Hornsea Project Four

Clarification Note Revised Ornithology Baseline

Document Reference: G5.40

Figure 23: Predicted results for best-fitting guillemot model. Response refers to the number of birds identified per transect segment in the observation data.

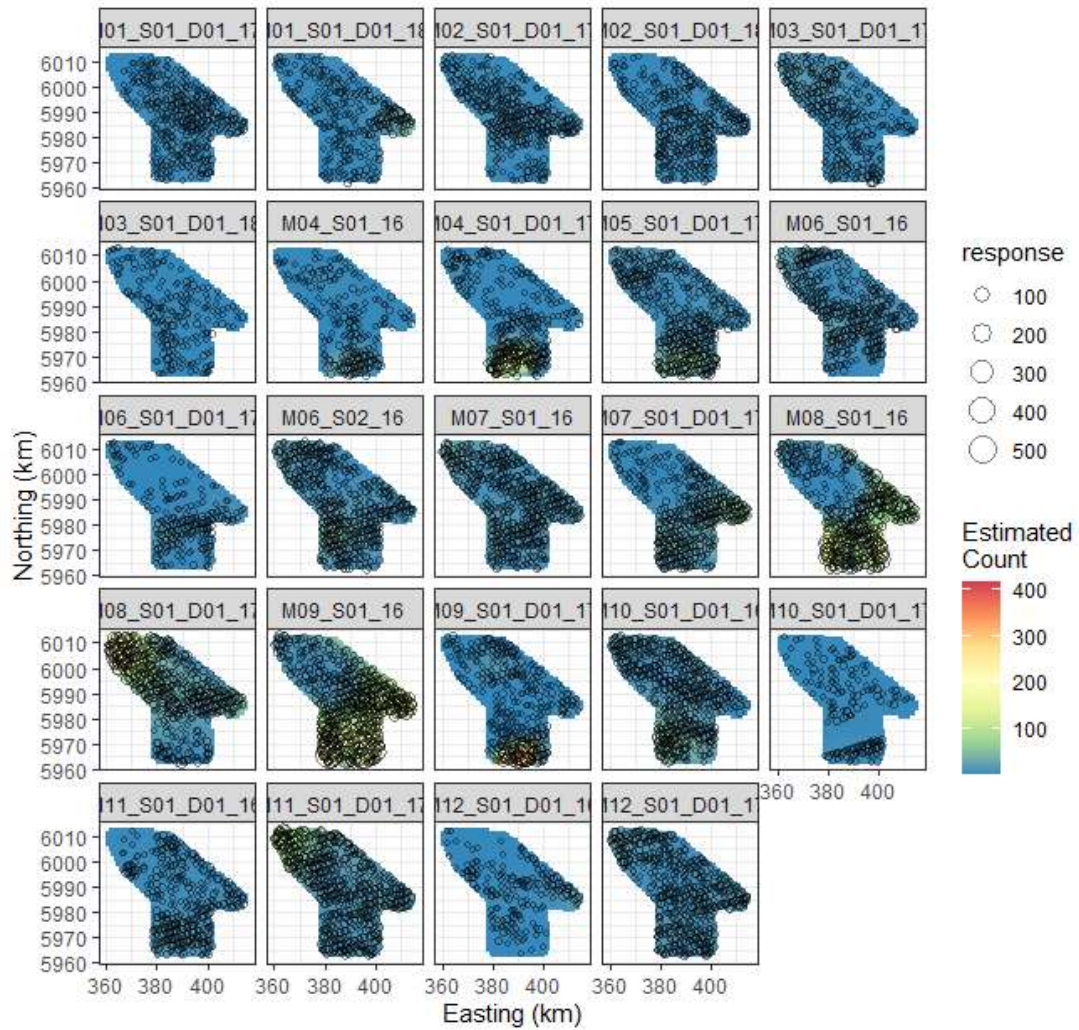
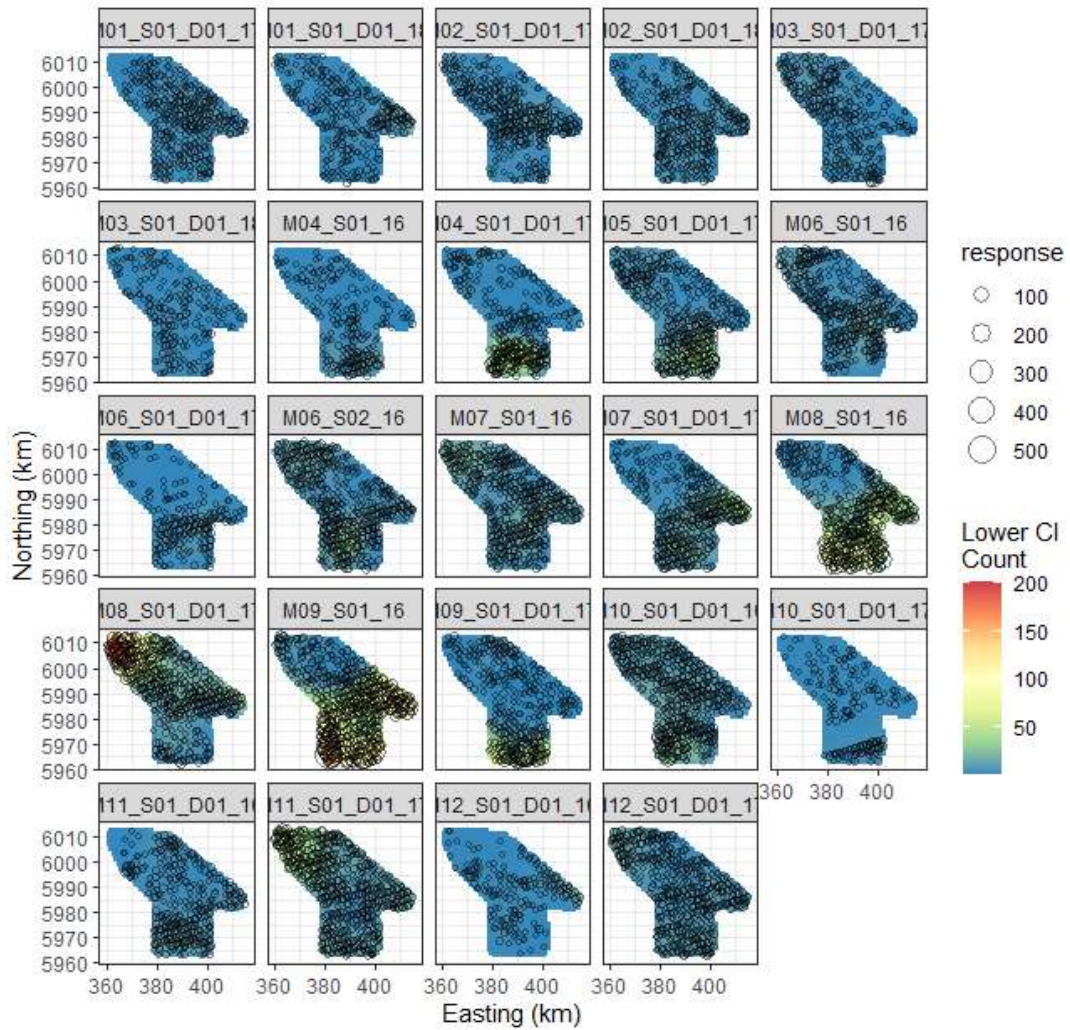
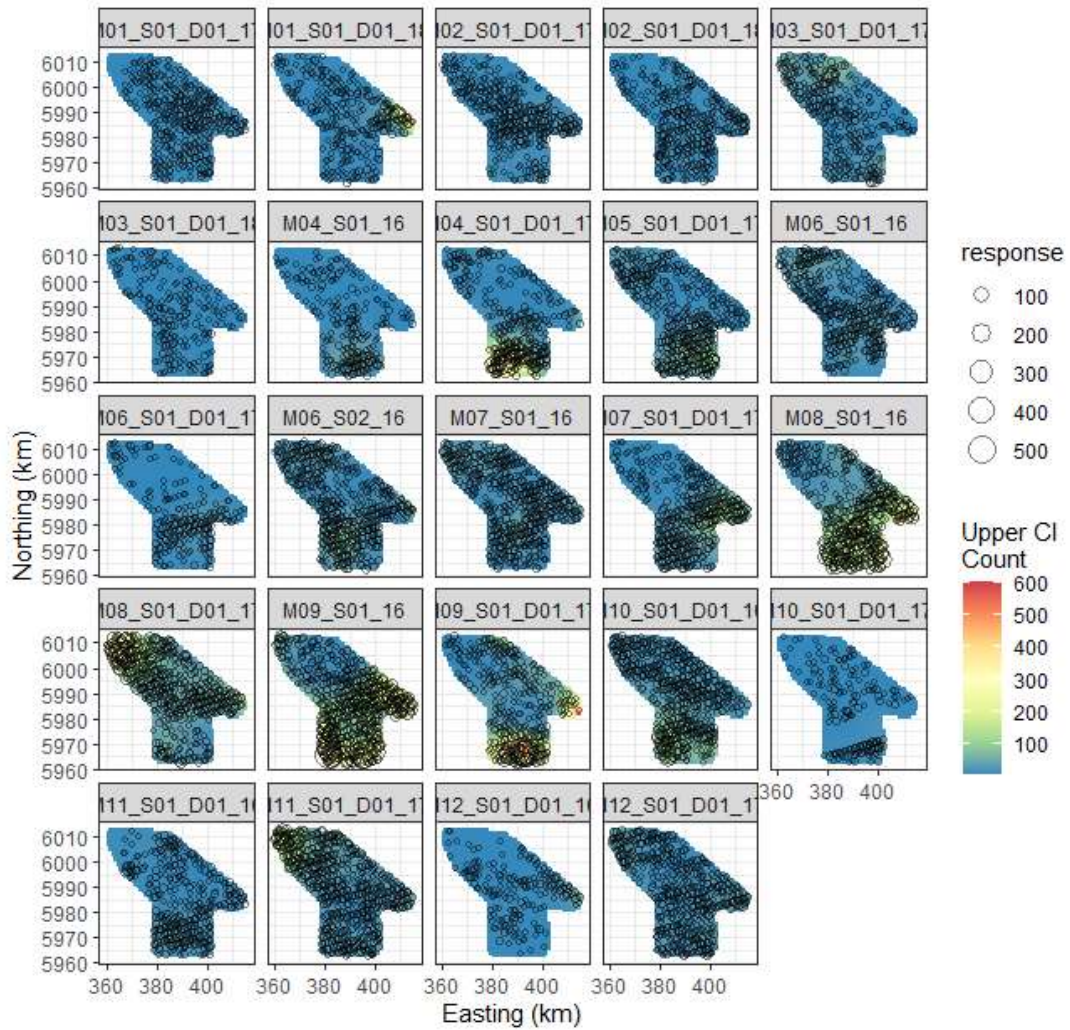
1.3 **2. Could clarification be provided on how the model outputs are ordered for guillemot in Figures 23-25 of the revised baseline document? It looks like there might be a month/year labelling system but it isn't clear.**

1.4 **3. There is one survey in Figures 23-25 where there appears to be no guillemot on several transects at all (M10_S01_D01_17). Could it be confirmed if this is correct, a plotting error or some other data treatment error?**

1.3.1.1 The naming convention of the model outputs for figures 23-25 in [G5.9 Revised Ornithology Baseline \(REP5-087\)](#) is based on the monthly survey IDs provided by the aerial survey provider for Hornsea Four. The naming convention is detailed below for an example survey:

M01_S01_D01_17 = January 2017 survey

- M01: This denotes the survey month, in this instance M01 equates to January
- S01: This denotes the survey number for the month, an example where this might deviate from being S01 is where two surveys in a single month are required due to a survey being missed in a previous month (e.g May 2016 survey was completed in June 2016).
- D01: This denotes the day of the survey if conducted over multiple days. For Hornsea Four all surveys were completed in a single day.
- 17: This denotes the year of the survey, in this instance 17 equates to the year 2017.

1.4.1.1 As detailed in [A5.5.1 Environmental Statement Volume A5 Annex 5.1 Offshore and Intertidal Ornithology Baseline Characterisation Report \(APP-074\)](#), four transect lines were not completed during the October 2017 (M10_S01_D01_17) due to poor weather conditions, hence why there is an area where no guillemots were recorded.
